From: Simon Davis
Sent: 21 May 2021 13:38
To: 'Jonathan Puplett' [REDACTED]
Cc: 'Gareth Giles | Whaleback' [REDACTED]
Subject: RE: BR/107/21/PL 283-285 Chichester Road Bognor Regis PO21 5AH

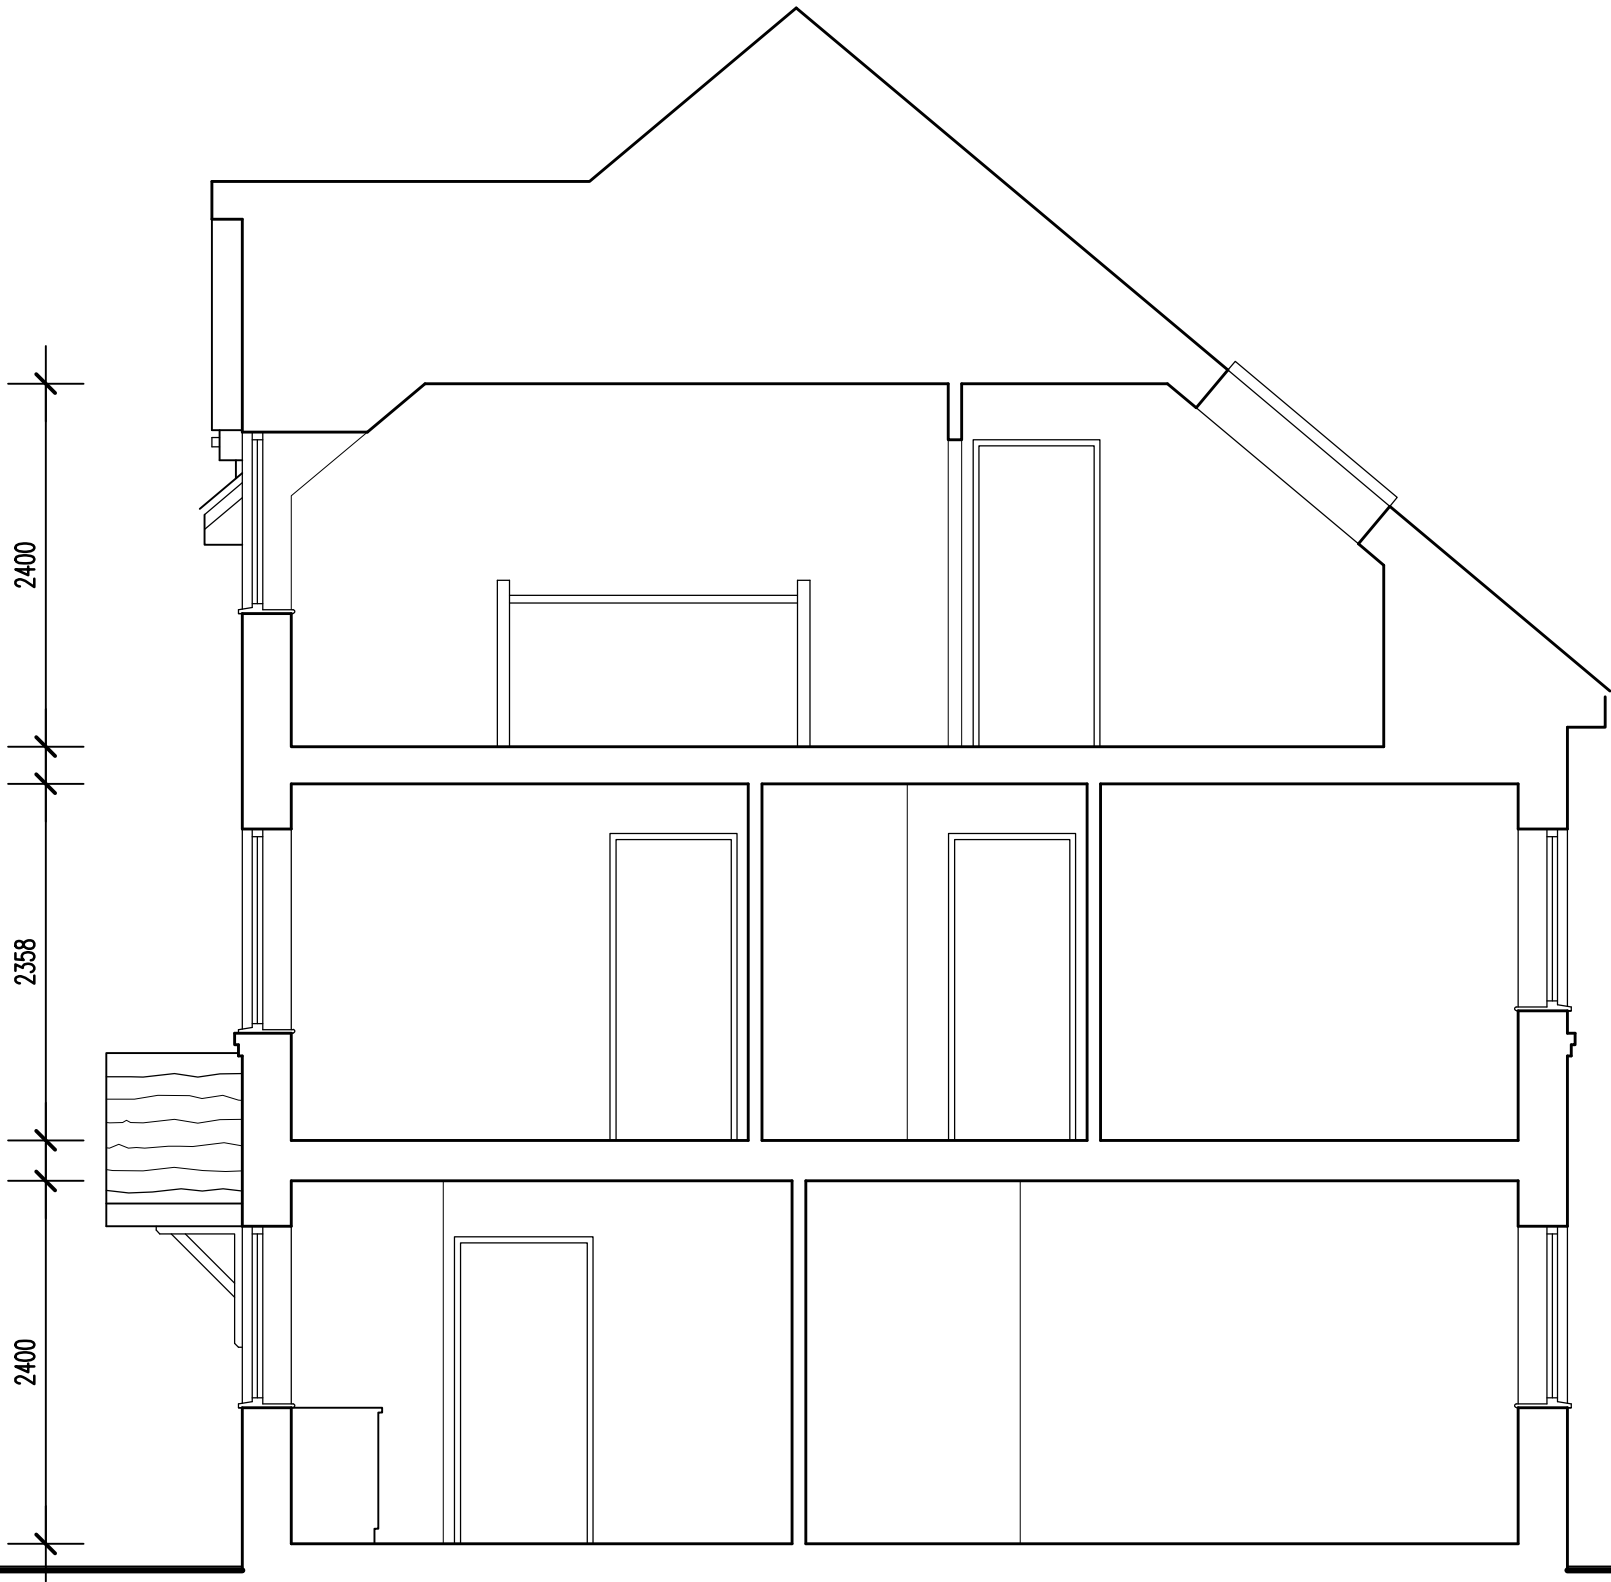
I had a chat with my Team Leader about this one yesterday. We have a current concern re the increase in height from two storeys to three and we will need to consider this further. I do acknowledge the three storey building opposite but this is also a prominent location which draws the eye when approaching from the north. In order to assist us in this, can you provide us with a streetscene drawing showing the proposed building alongside the existing adjacent buildings. Please also indicate whether there will be any change in ground and finished floor levels. Can you give me a timescale on when you can get this information to me.
